**From:** ENVU Biodiversity and Land Use  
**Sent:** 15 January 2026 09:36  
**To:** Planning ContactCentre  
**Subject:** 2025/93355 at location Land off, Woodward Court, Mirfield, WF14 0PY

Please see ecological commentary below:

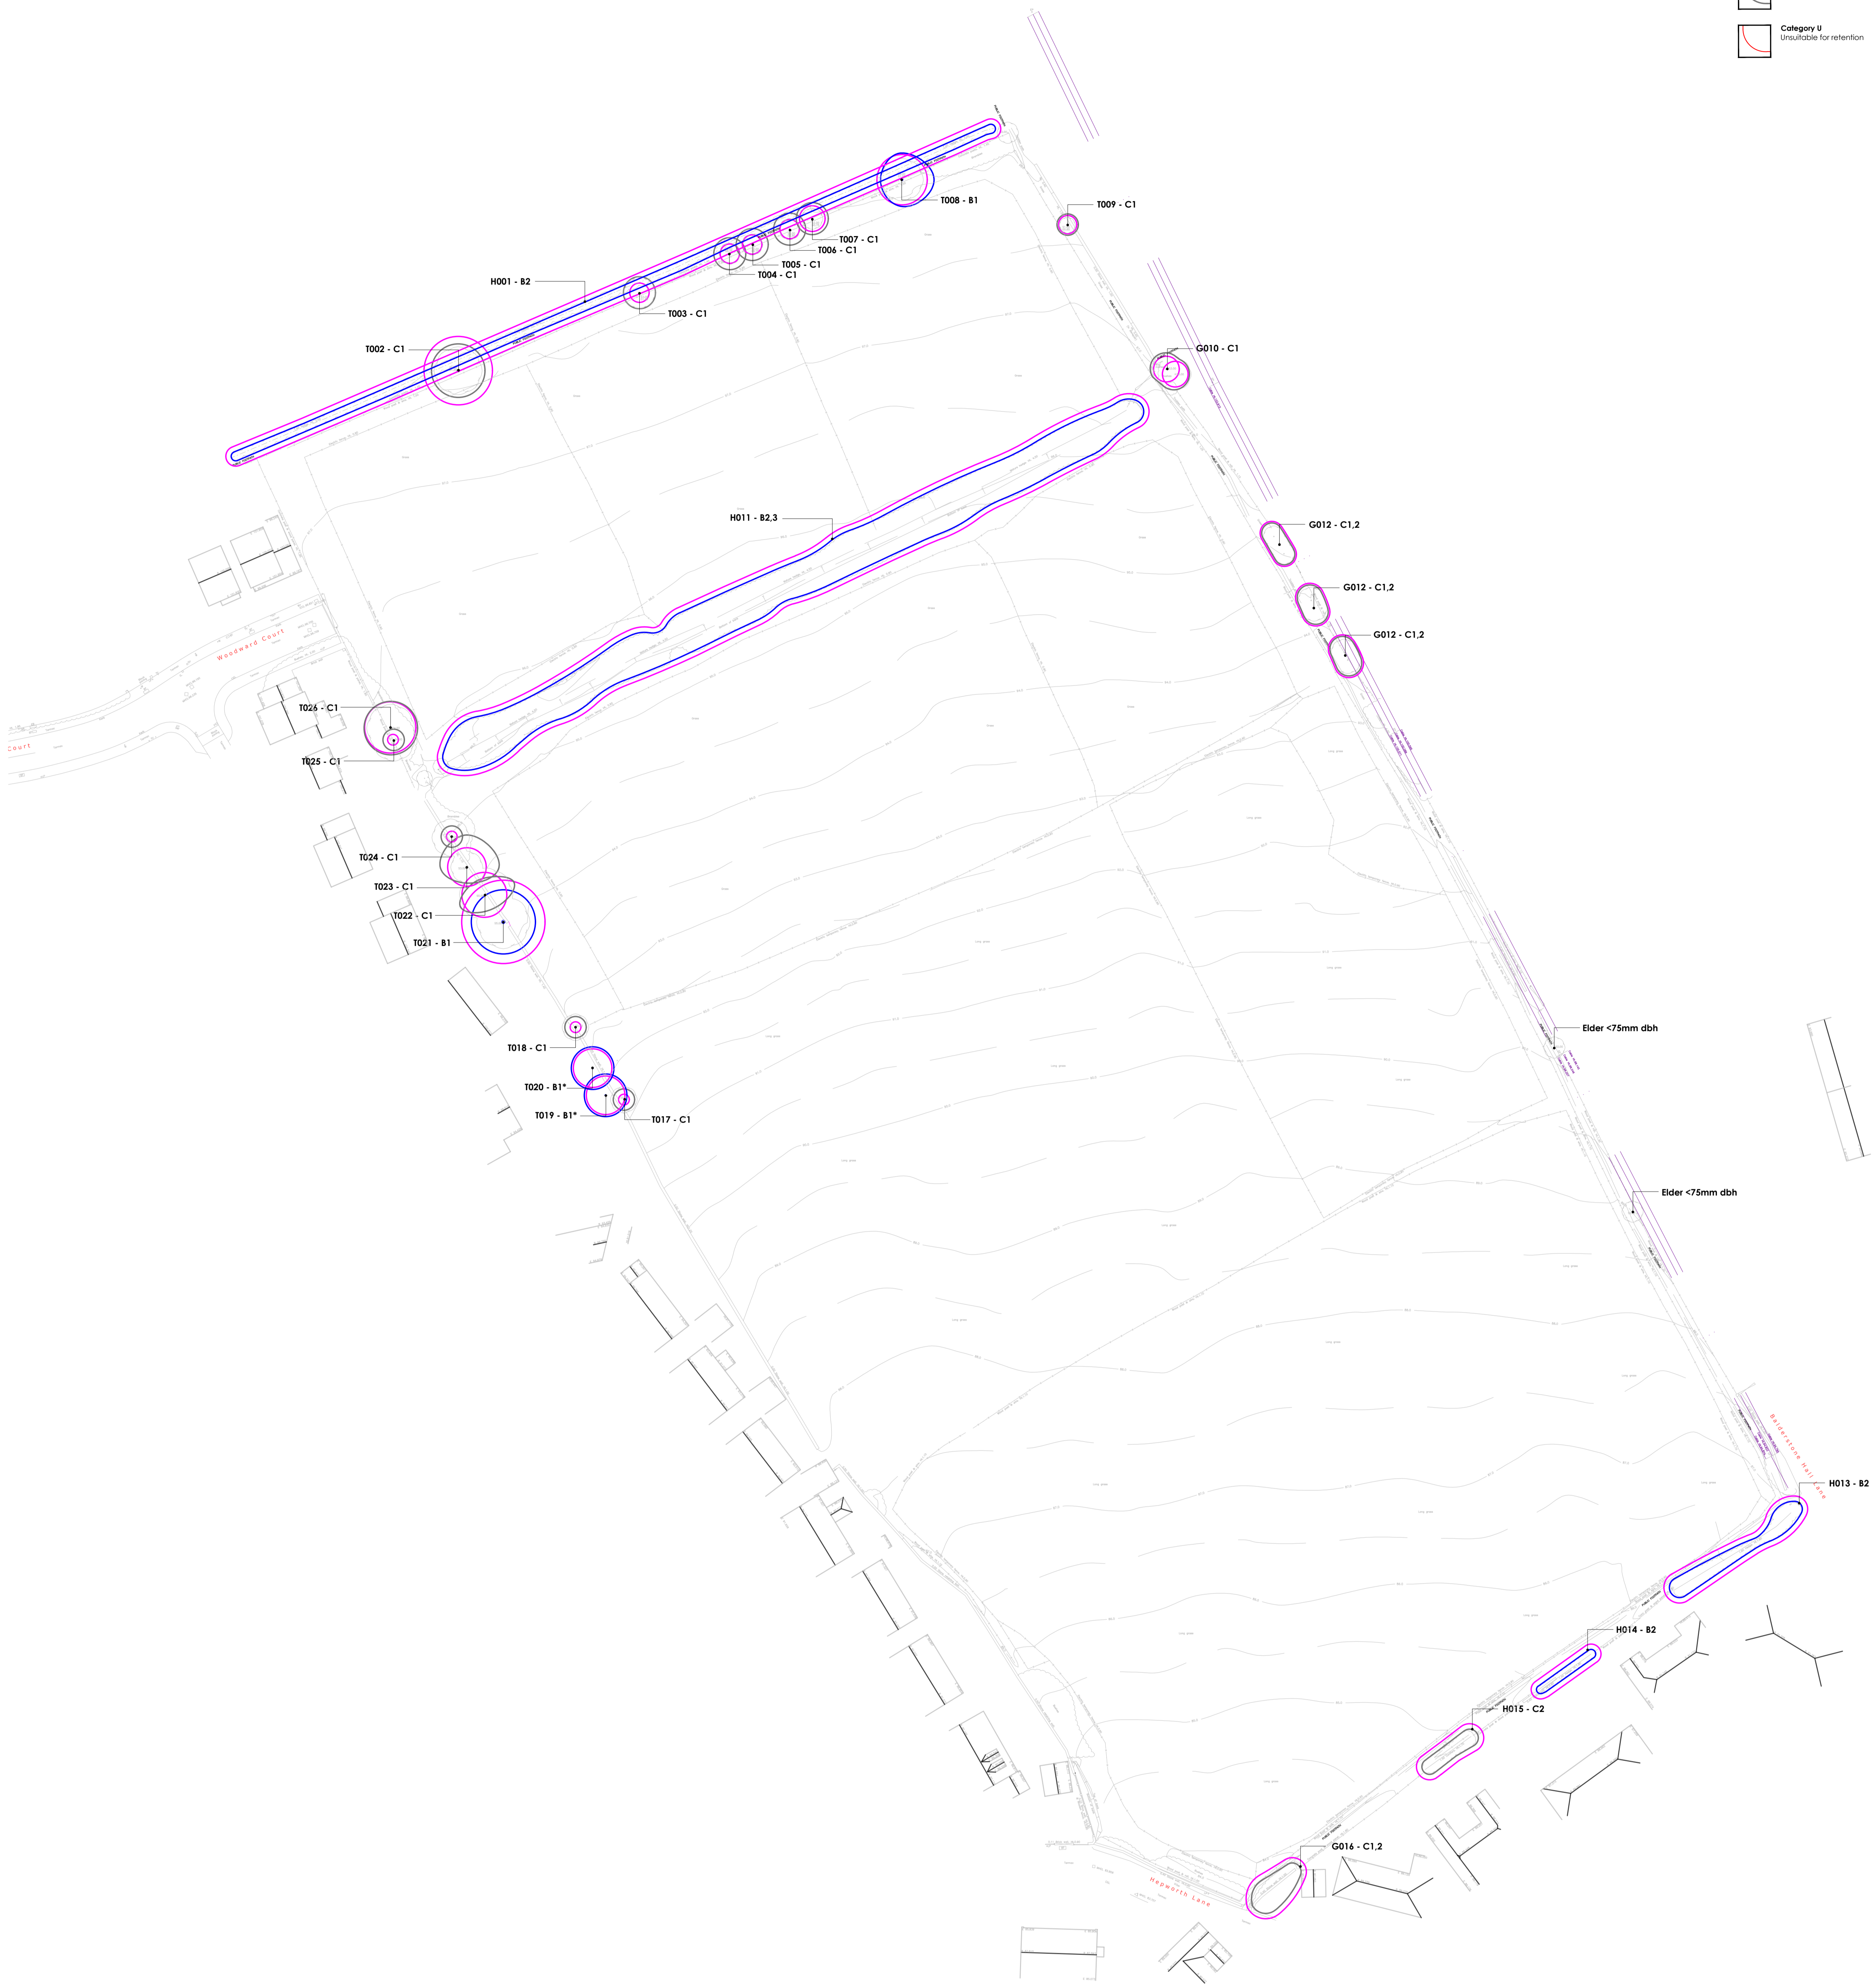
- foraging / commuting badgers (with suitability for setts building in the wider area). Pre-commencement surveys will be conditioned as a result.
- 'Moderate' suitability for foraging and commuting bats, with a mature tree suitable for roosting bats (TN1) adjacent to the southeast boundary of the site. Tree protection and lighting strategy conditions will be added. **Bat activity surveys will also be required to understand the value of the site to foraging / commuting bats. These surveys must be completed during the bat activity season (May – August).**
- for foraging and nesting birds, reptiles, invertebrates, and hedgehog – A CEMP has been provided for review of precautionary measures, one will be conditioned as a result of the recommendations provided.

A Hedgerow and Tree Protection Plan detailing measures for the protection of trees and hedgerows during the works will be submitted to and approved by the LPA prior to the commencement of works on site, including site clearance and delivery of materials.
